Our Reference: SYD18/01322/19

Departments Reference: SSD 9522

**RESPONSE TO SUBMISSIONS - KEMPS CREEK WAREHOUSE, LOGISTICS AND INDUSTRIAL FACILITIES HUB (SSD 9522)**

Figure 4.5. Bakers Lane Intersection (initial)

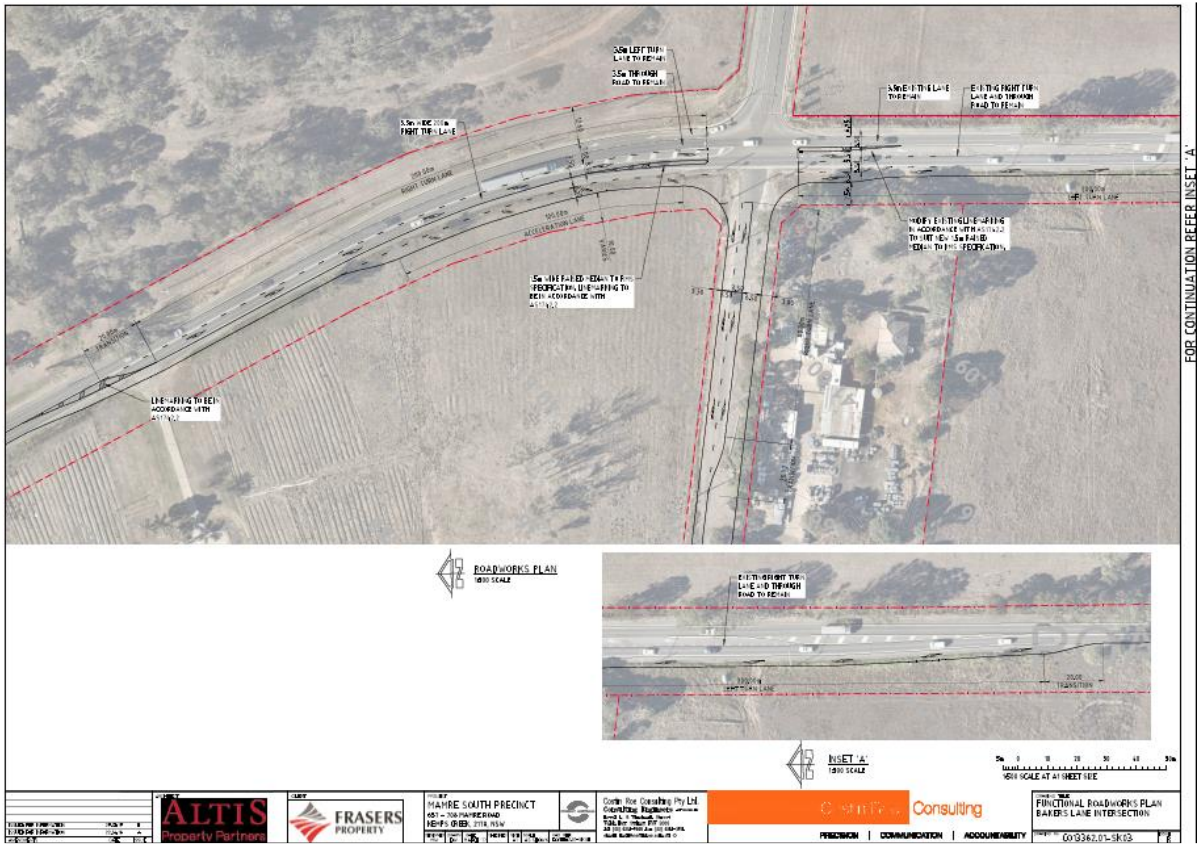
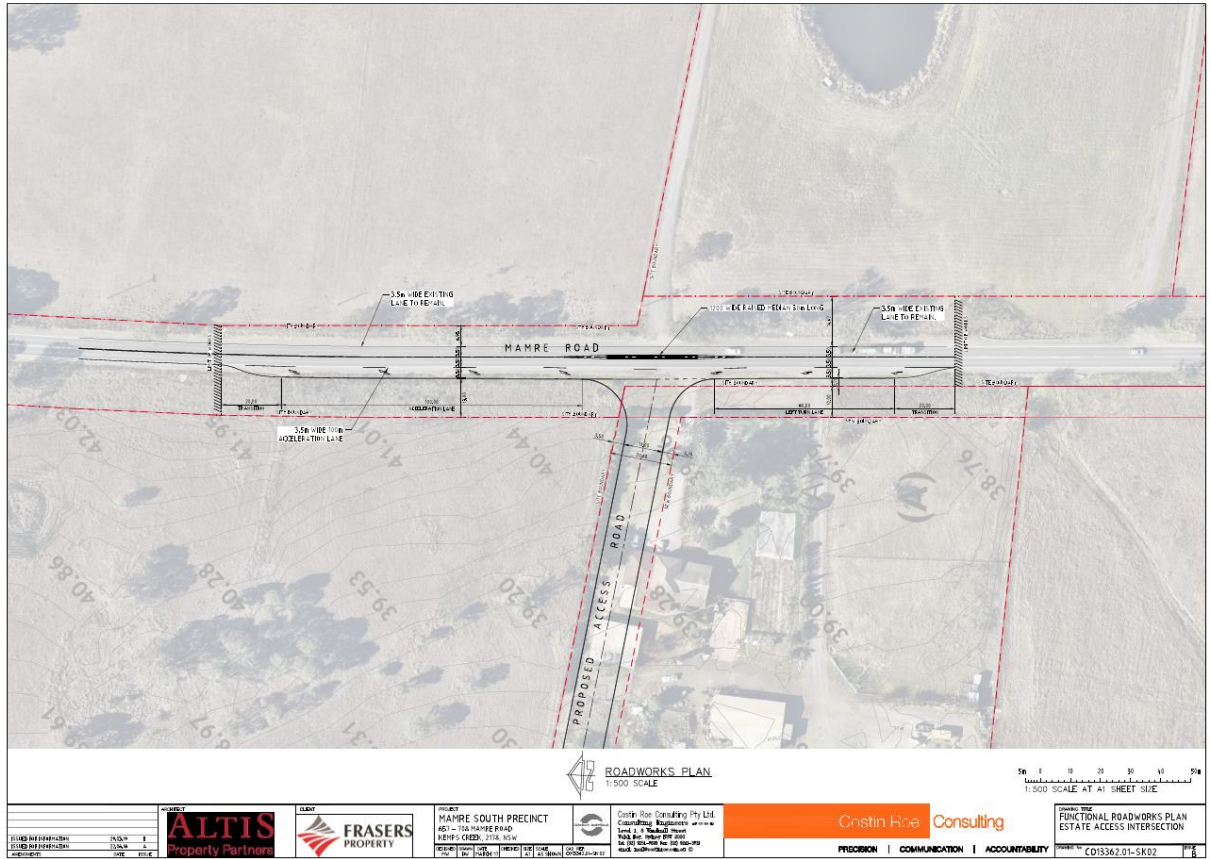
The intersection of Bakers Lane and Mamre Road in the sequence 1A & 1B is not consistent with the ultimate TfNSW design for the intersection of Southern Link Road (SLR) and Mamre Road. The preliminary information provided for review by Altis/Fraser in March 2020 by Costin Roe Consulting provided the following intersection sequences:

- a. Sequence 1A has alignment with current Bakers Lane alignment.
- b. Sequence 1B has alignment matching current Bakers Lane alignment but widened to be consistent with the Mamre Road upgrade width and wide medians.
- c. Sequence 2 has the alignment with proposed SLR and Mamre Road alignment.
- d. Sequence 3 appears to be ultimate design with SLR continuing west through the development.

Recent designs for Sequence 1A & 1B provided by MUGroup on behalf of Fraser Property Group indicate that there is a departure from the abovementioned alignment of the wider medians required to be consistent with the Mamre Road upgrade. TfNSW provided further comments in letter dated 22 July 2020 see **Attachment A – TfNSW letter** on this matter indicating concerns with the proposed changes for the applicant to consider. TfNSW is currently assessing further updated documentation in response to this letter from the applicant.

The signal designs being presented in the development application should be consistent with plans being discussed with TfNSW to ensure that the approved development application design meets TfNSW requirements. It is recommended that further refinement

and clarification of the abovementioned sequences are undertaken to ensure that the concept plans meet TfNSW requirements for a safe and efficient intersection.

Annexure A - Mamre Road Works PlanA handwritten signature in black ink, located in the bottom right corner of the page. The signature is stylized and appears to be a cursive or semi-cursive script.

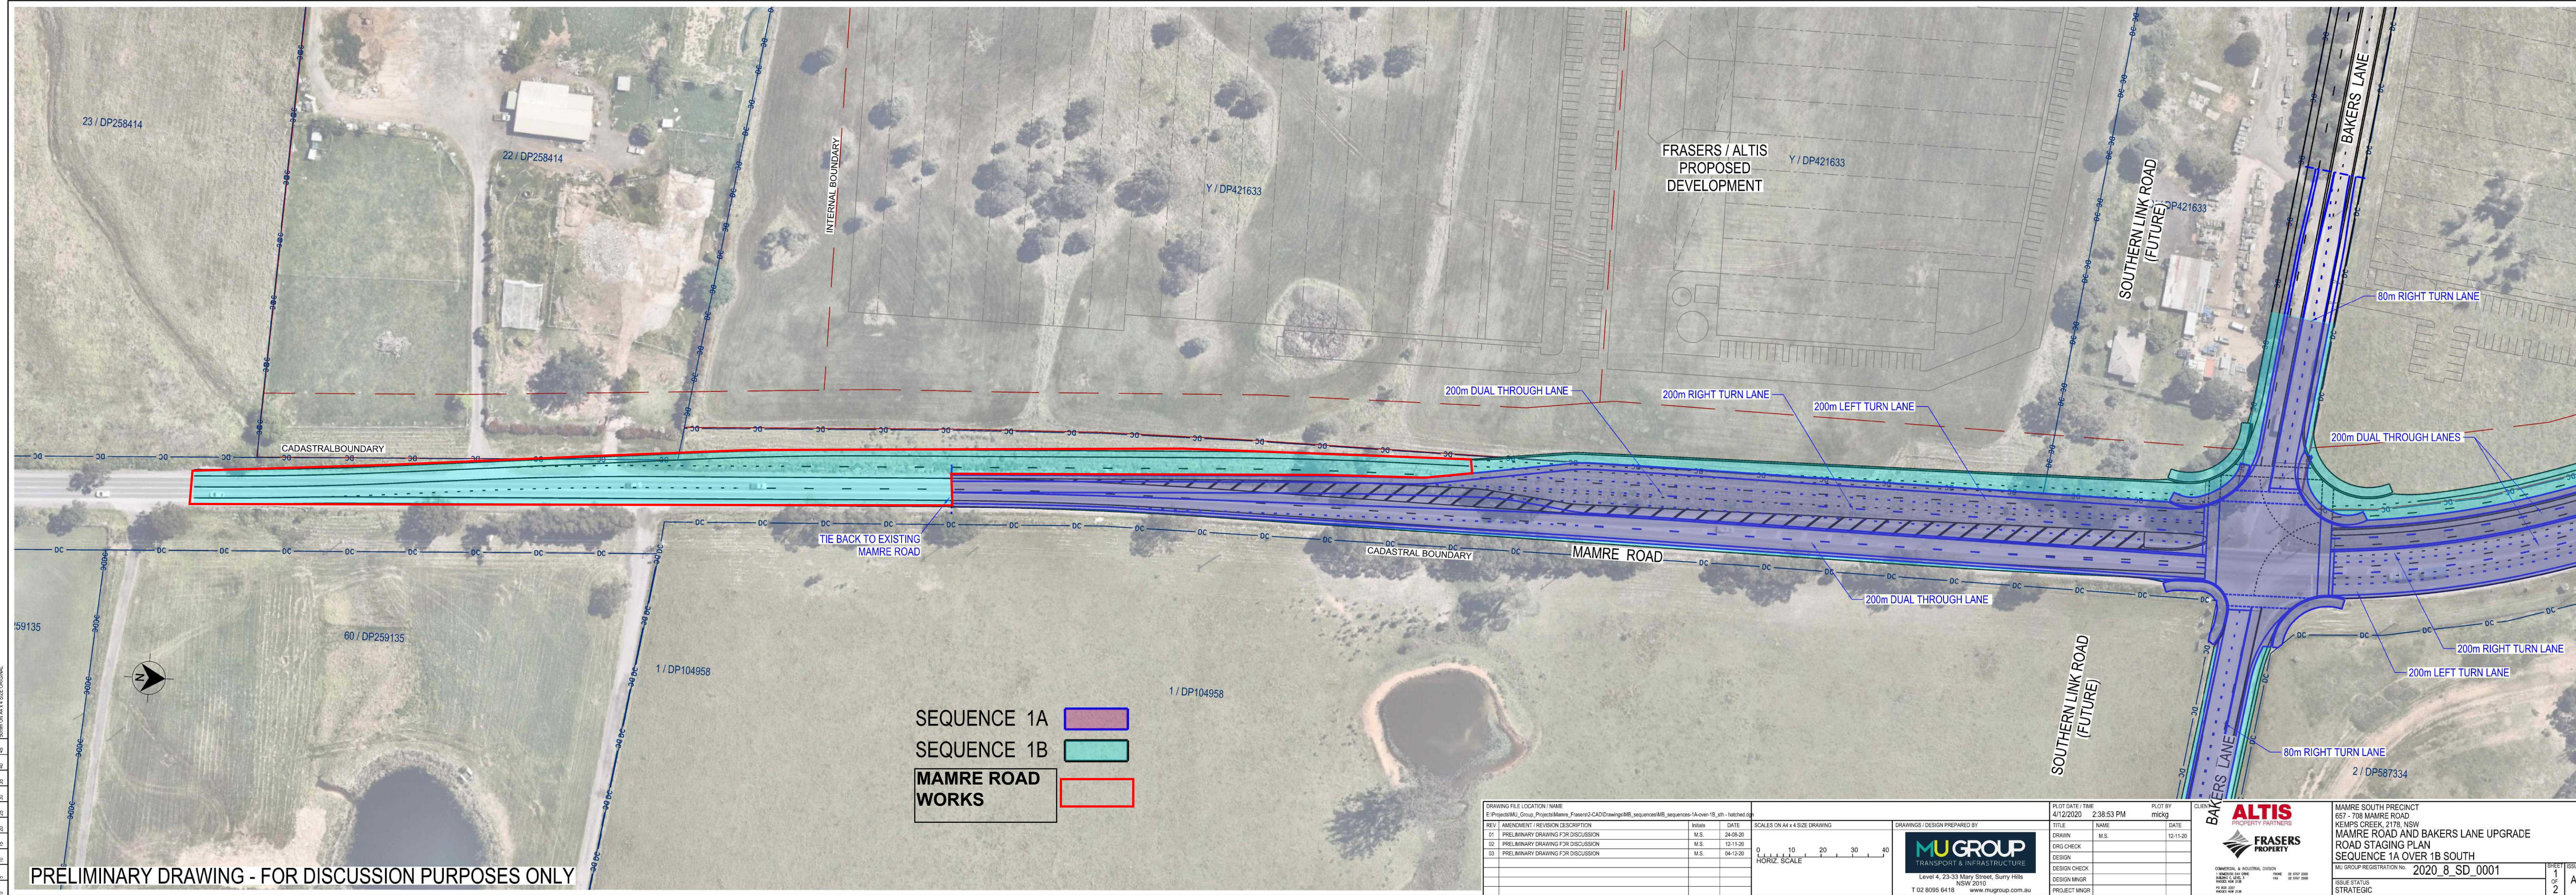
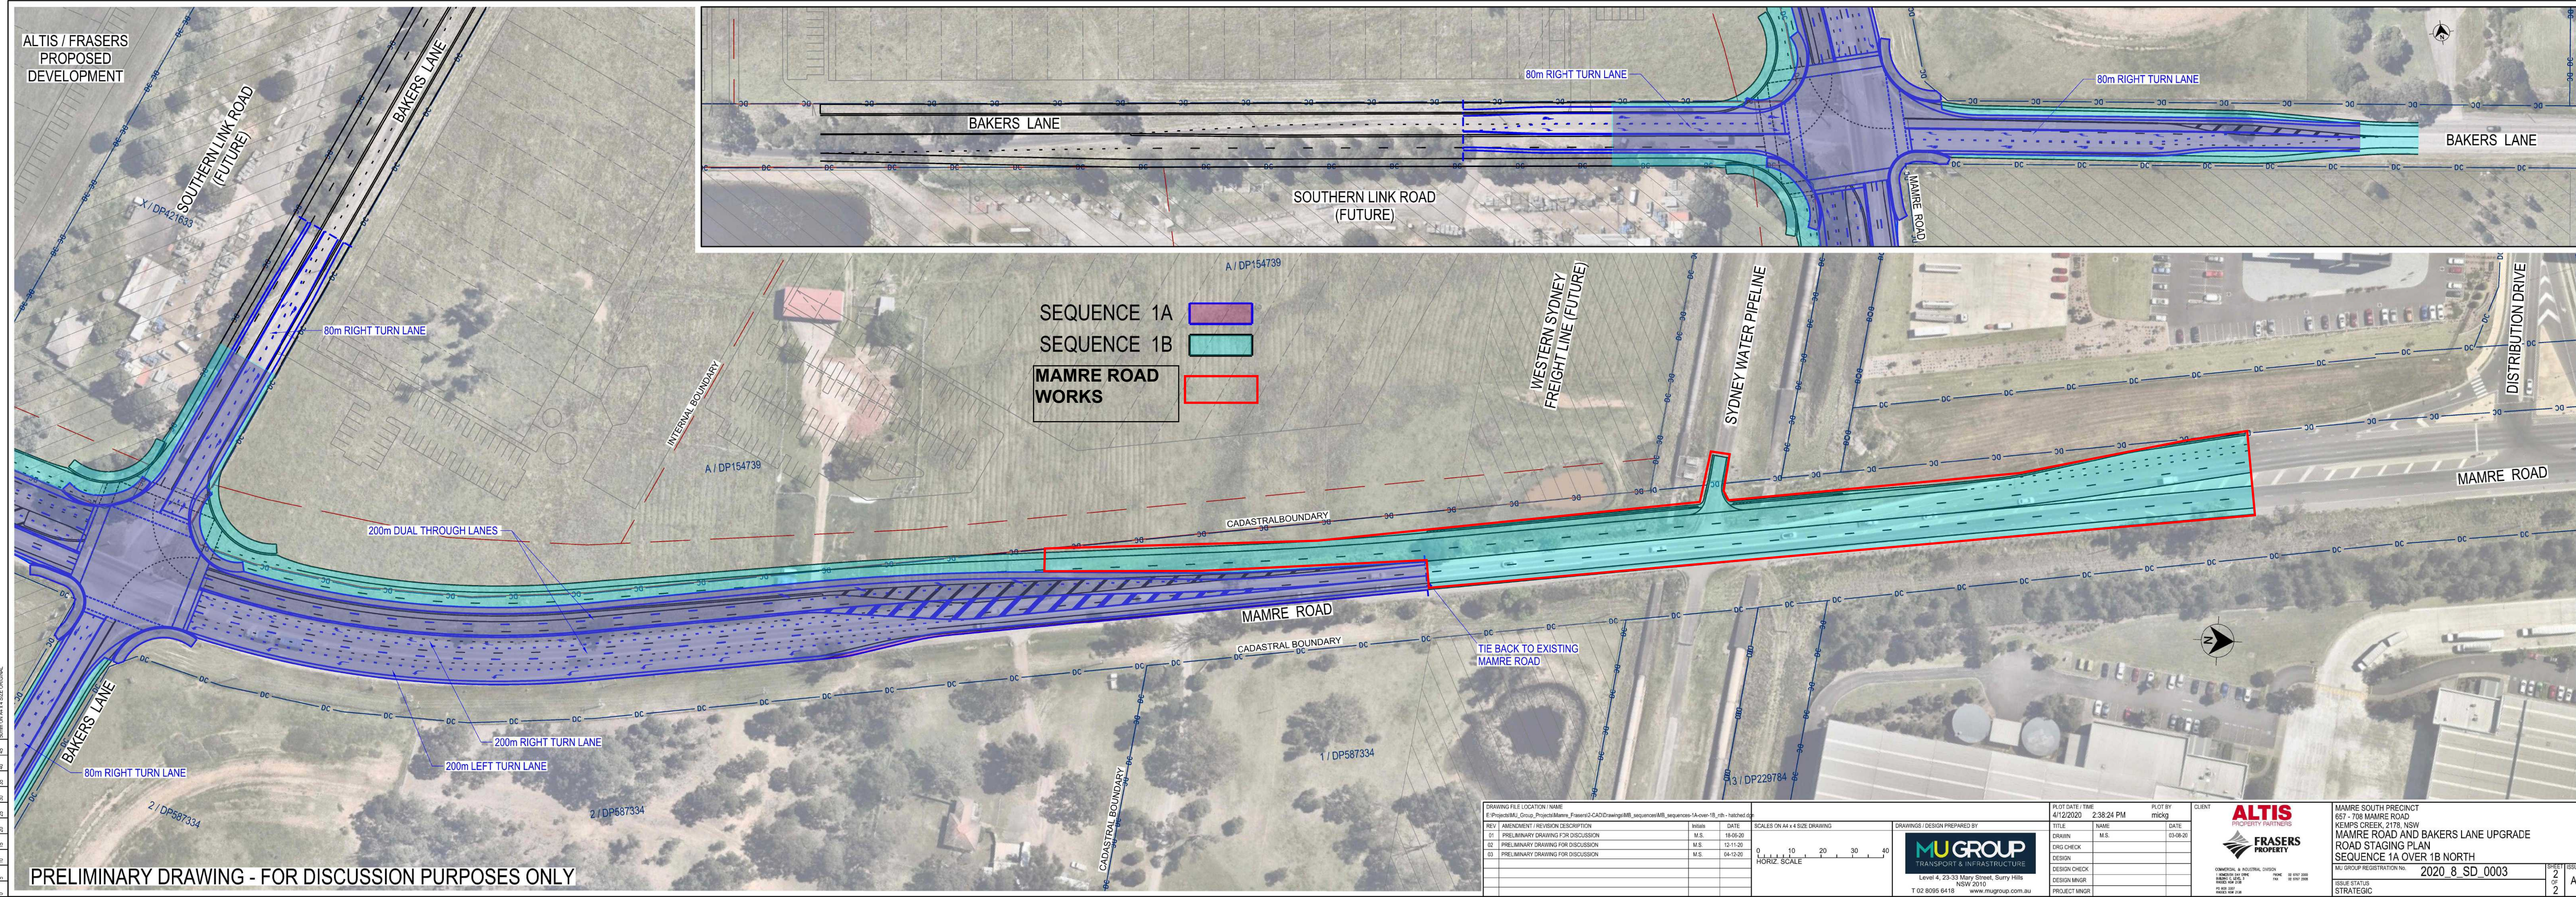
1. It is noted that the MU Group Strategic Road Design for Mamre Road / Southern Link Road (SLR) differs from all other designs and is a departure from previous correspondence provided to assess this application. the following comments are provided for Altis/Fraser to consider:

- a. The design does not cater for the upgrade design ie wide medians and alignment with future SLR. This is a departure from preliminary design for the development which had alignment of Mamre Road at what appeared to be the consistent with the TfNSW Mamre Road Upgrade design.

- b. From the drawings from MU Group, the boundaries, especially the detailed boundary around the intersection at Bakers Lane is not consistent with the overall strategic design for Mamre Road and SLR. It should be noted that the boundaries previously sent were consistent with the DPIE boundaries in the Mamre Road Precinct for road reservation. It is recommended that Altis/Fraser and their designers should review the drawings and at a minimum match the road reservation boundaries.

- d. The intersection which consist of Bakers Lane and Mamre Road in the design by MU group is not consistent with the ultimate TfNSW design for the intersection of SLR and Mamre Road. The preliminary information provided for review by Altis/Fraser in March 2020 by Costin Roe Consulting provided the following intersection sequences:

The design by MU Group appears to be a departure from Preliminary design from Costin Roe Consulting. The new design raises questions such as, will this design only cater for Sequence 1A? Will additional design for Sequence 1B and Sequence 2 be also available for review by TfNSW?

4. Raised medians with signal posts are required on Mamre Road, due to the wide 5 lane approaches.
5. Raised medians should be considered on Baker Street to provide separation from heavy vehicle turning movements.
6. T1 turn lines are incorrectly located and are not required for single turns.
7. Swept paths for the 26 metre B-double design vehicle per report are to be provided.

8. The modelling for southbound vehicles turning right into Bakers Lane shows a maximum queue length of 216.5 metres, however the design shows a right turn bay of 200 metres. There is a safety risk with vehicles queuing in the right turn bay overflowing into the through lane if there is insufficient storage length. It is recommended that the design is updated to ensure that the maximum queue lengths can be accommodated in the design.
